MECKLENBURG COUNTY
Park and Recreation Department

MEMORANDUM

DATE: December 19, 2023

RE: Rezoning Petition #2023-155
PID# 03714104

TRINITY PARK TOWNHOMES

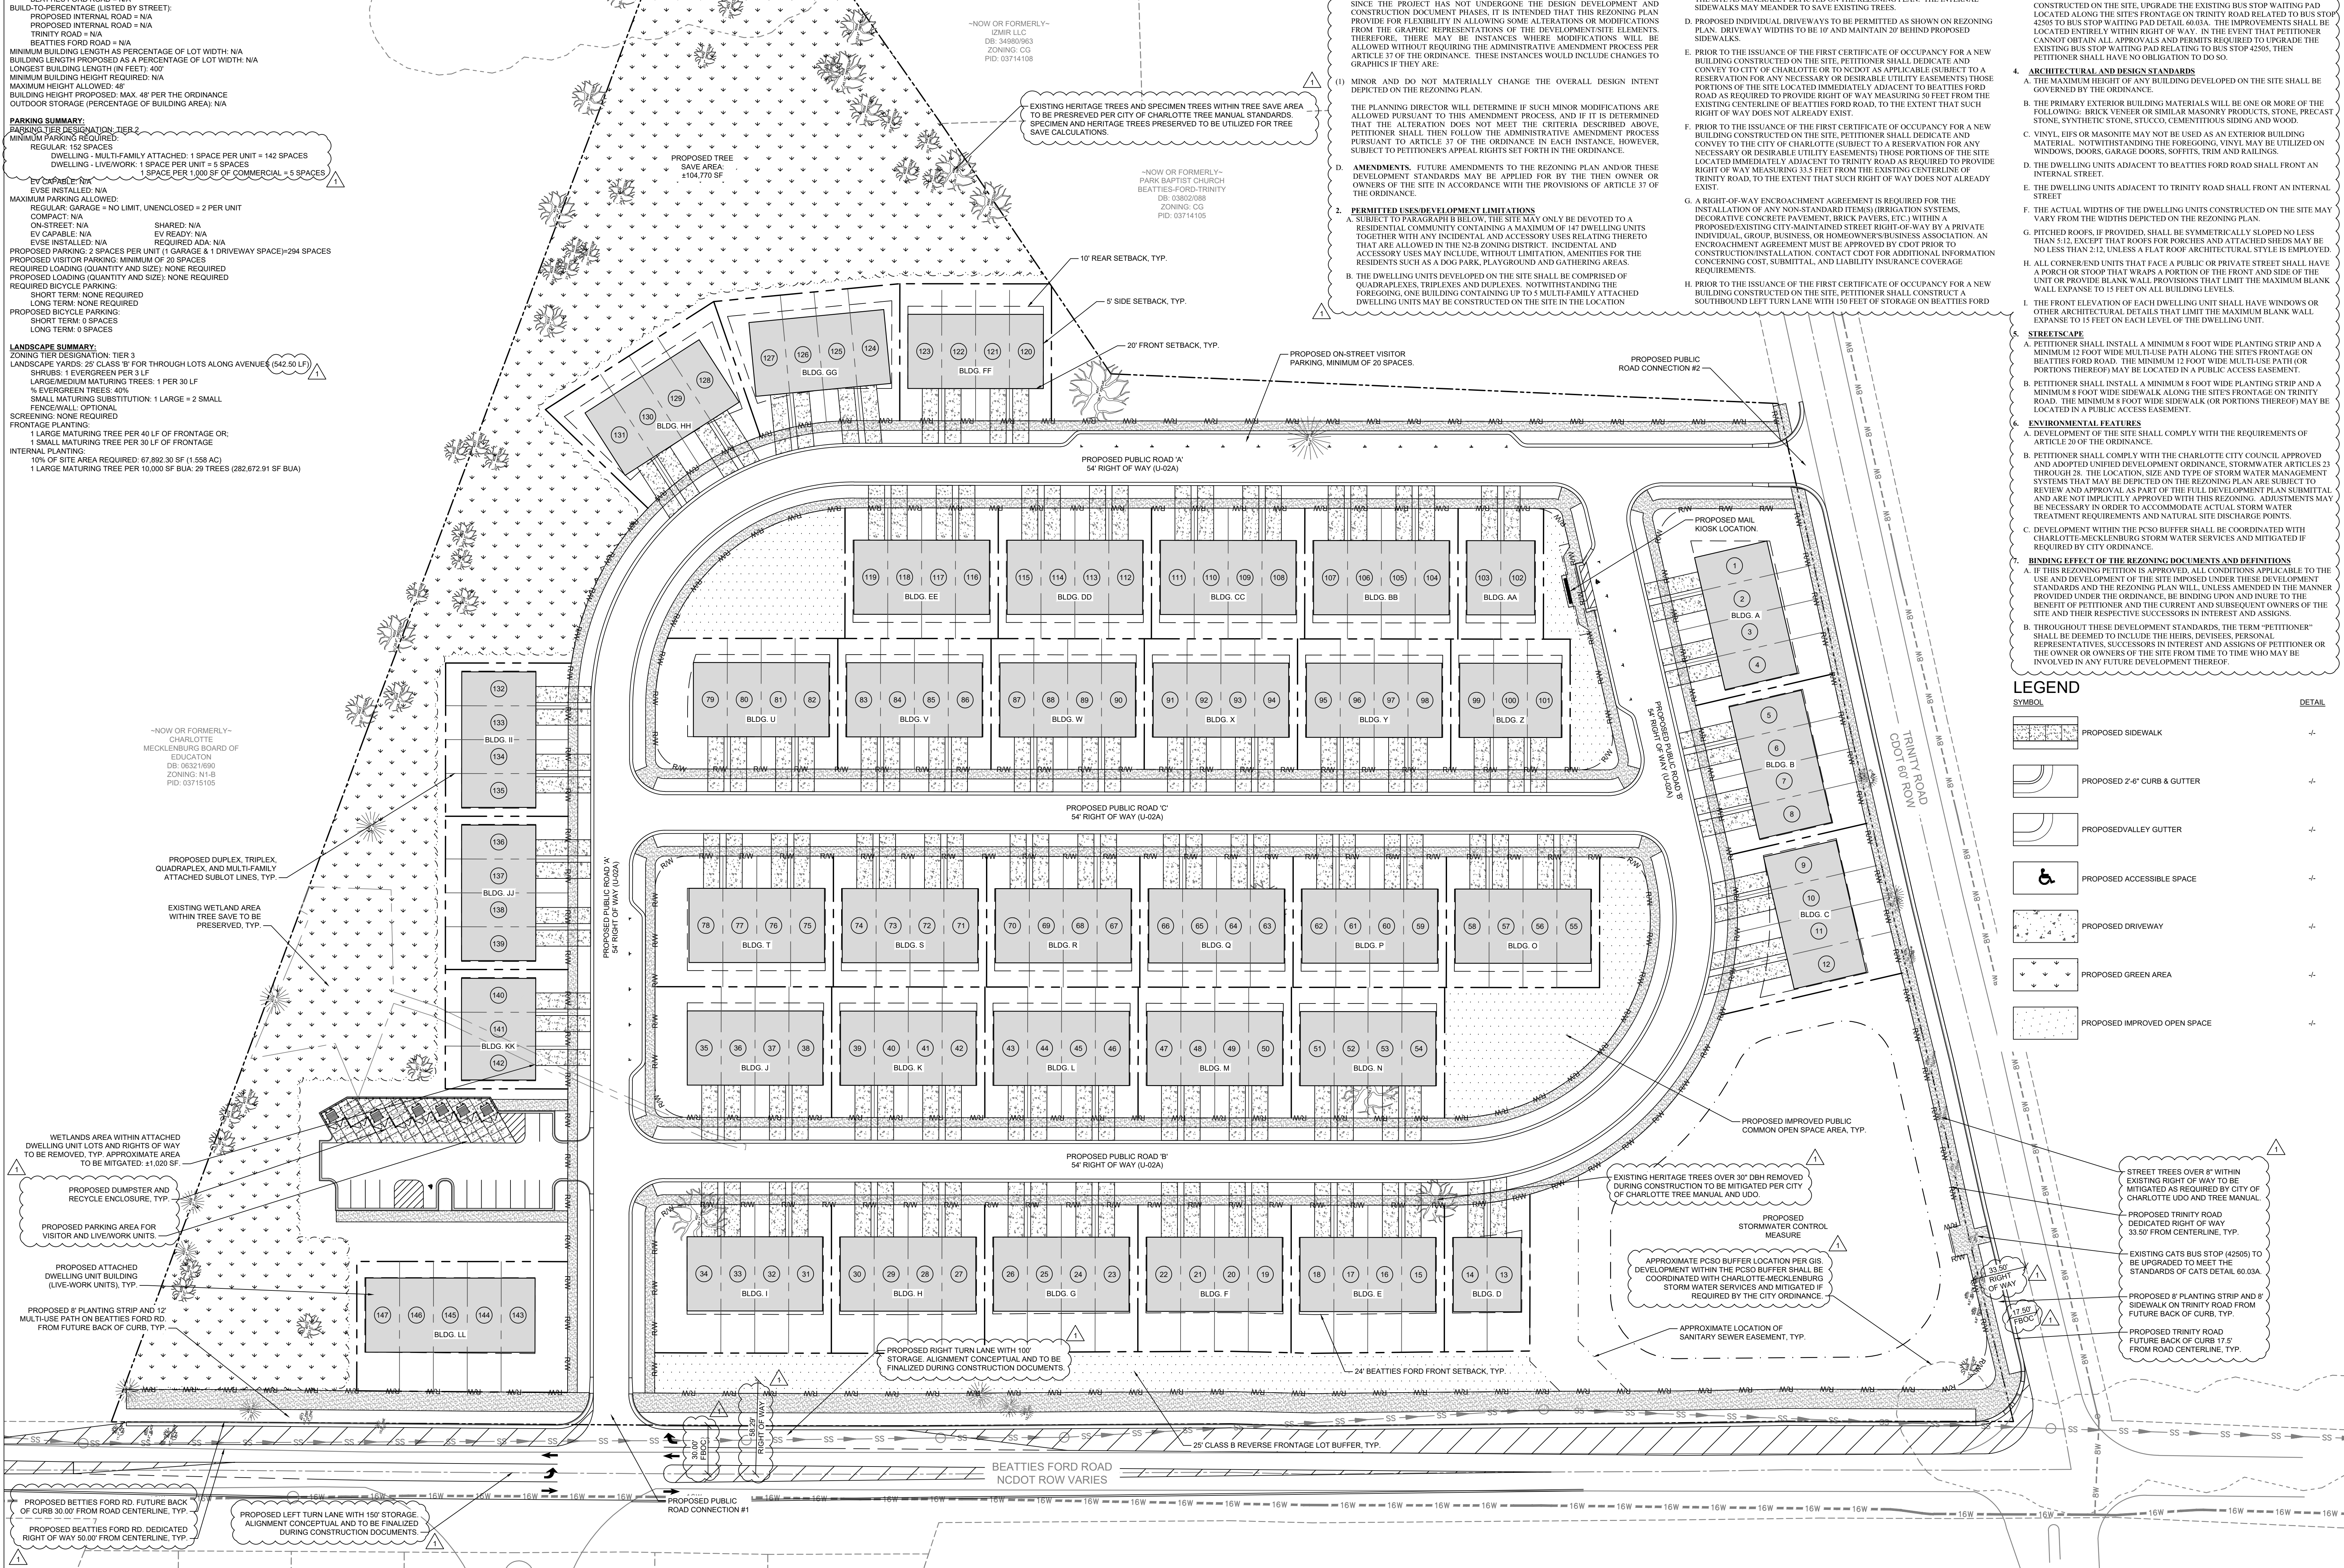
MCPR requests that the petitioner provides pedestrian connectivity to Hornets Nest Park via improvements to the intersection of Beatties Ford Road and Trinity Road.
